DOC20/490839-20, SF19/354 (SSD 9697)

**Bayswater Power Station Upgrade (SSD 9697)
EPA Advice on Response to Submissions Report**

Detailed review of surface water pollution issues of *Appendix B of the Response to Submissions*

Figure 5.3: Coal Handling Plant water management system (Source AECOM, 2017)

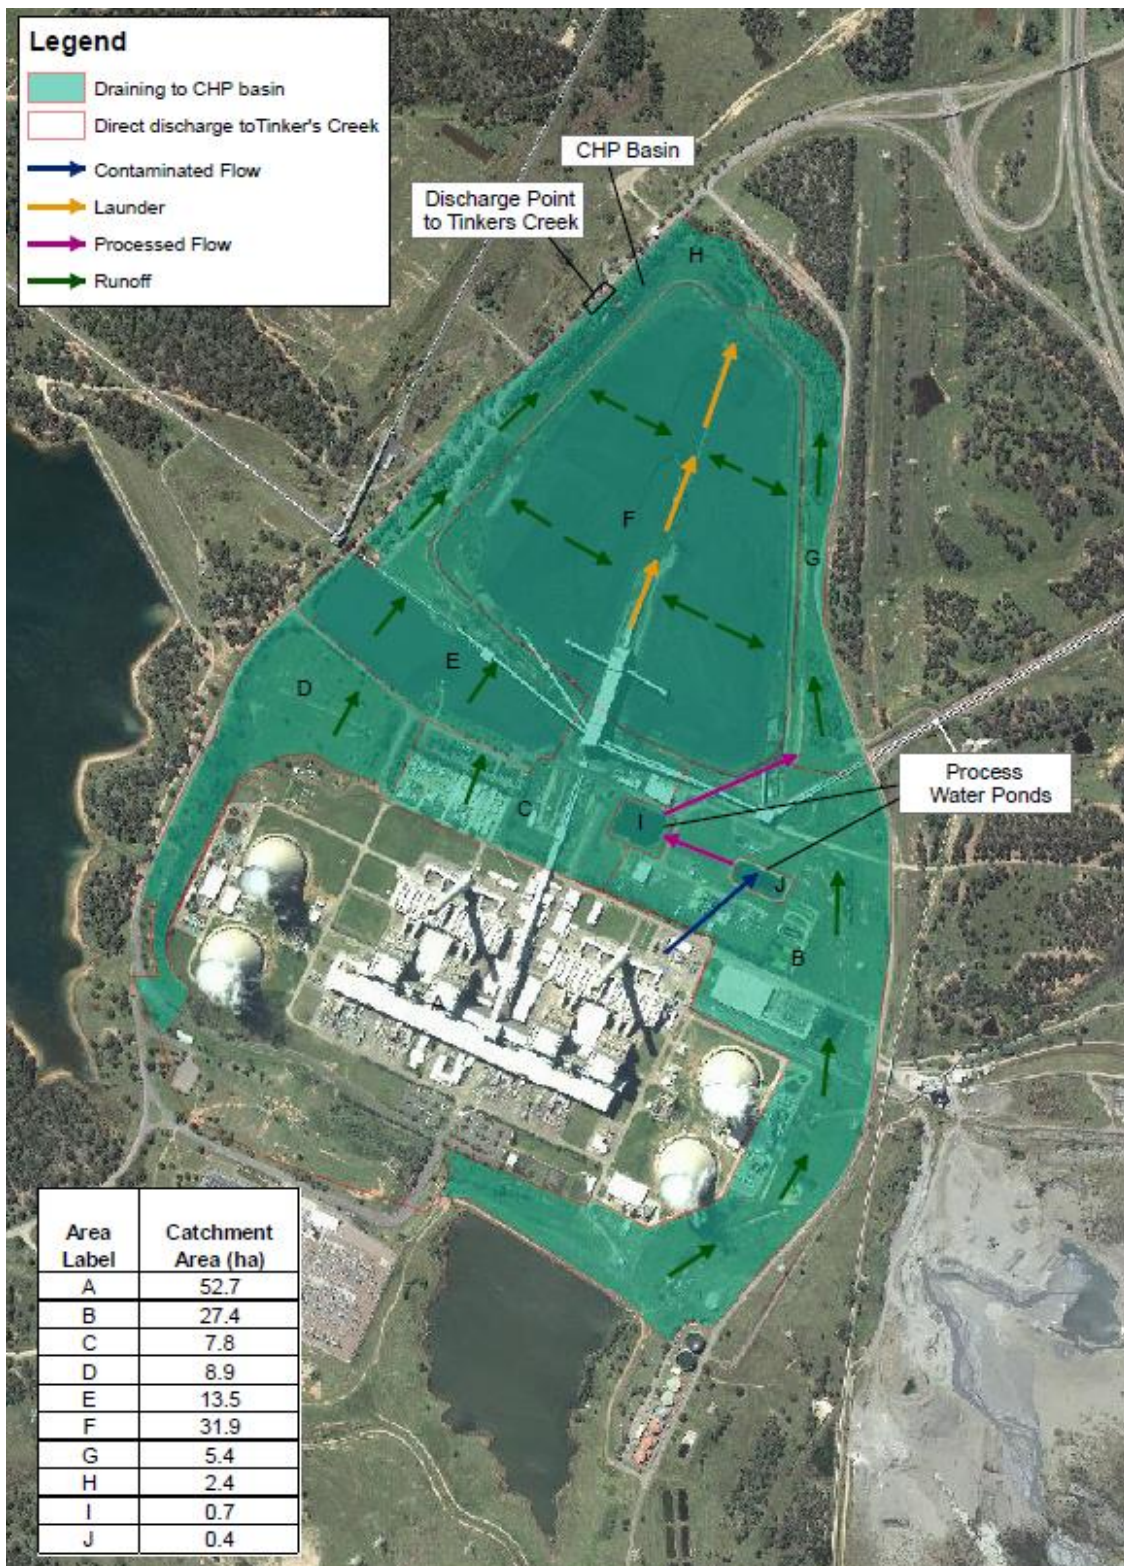
The assessment appears inconsistent with the proposed water management system. The RtS indicates that proposed changes to the coal handling plant water management system would result in reduced discharges to Tinkers Creek. However, the RtS states, 'for the purposes of this assessment it is assumed that the volume and frequency of water discharged to Tinkers Creek would not change'.

The RtS provides an overview of the proposed water pollution mitigation measures, committing to reuse water within the coal plant water system 'where possible', or operational purposes which 'could include water treatment'. However, the RtS defers details of the proposed water management system changes, including in relation to enlargement and reconfiguration of the coal handling plant sediment basin to detailed design.

Figure 6.5: Simulated Ash Dam pond water volume for post-augmentation conditions.

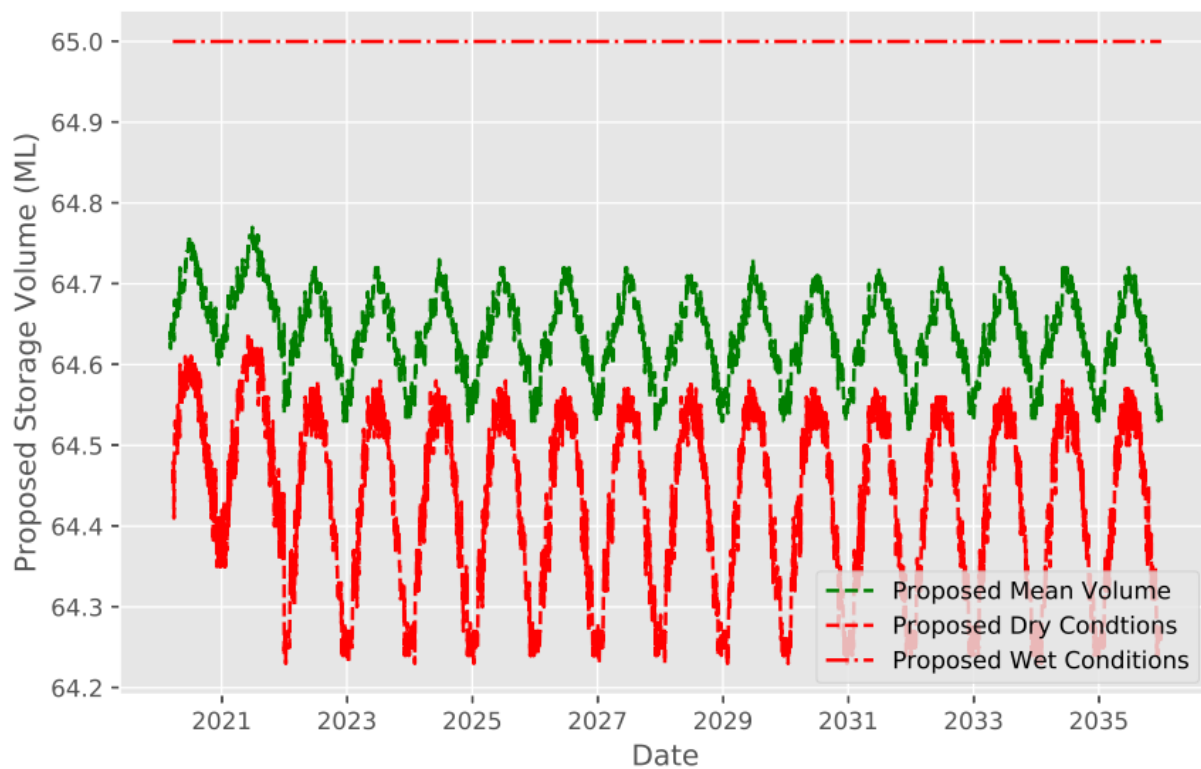
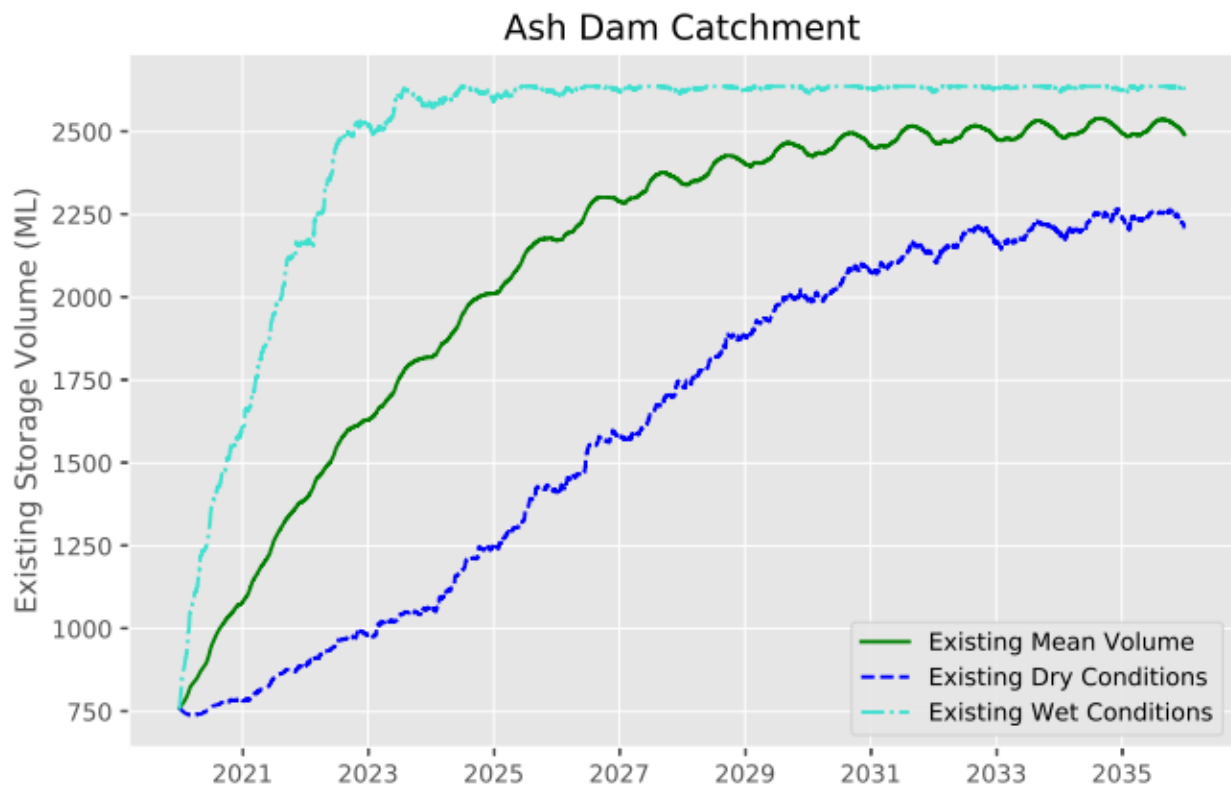
The ash dam water balance results presented in the RtS are unchanged from the EIS, predicting that the proposed development will result in:

- no overflows under the dry and average scenarios, with no change from the existing development
- overflows increasing from 50kL/day to ~2ML/day under the wet scenario
- substantial reductions in evaporation under all climate scenarios.

The RtS refers to shortlisted mitigation options which include ‘increase evaporation through mechanical evaporation to reduce volume/ frequency of overflows’ and ‘increase rate of evaporation via increased dust suppression of haul roads’ however it is unclear whether these options have been incorporated into the design.
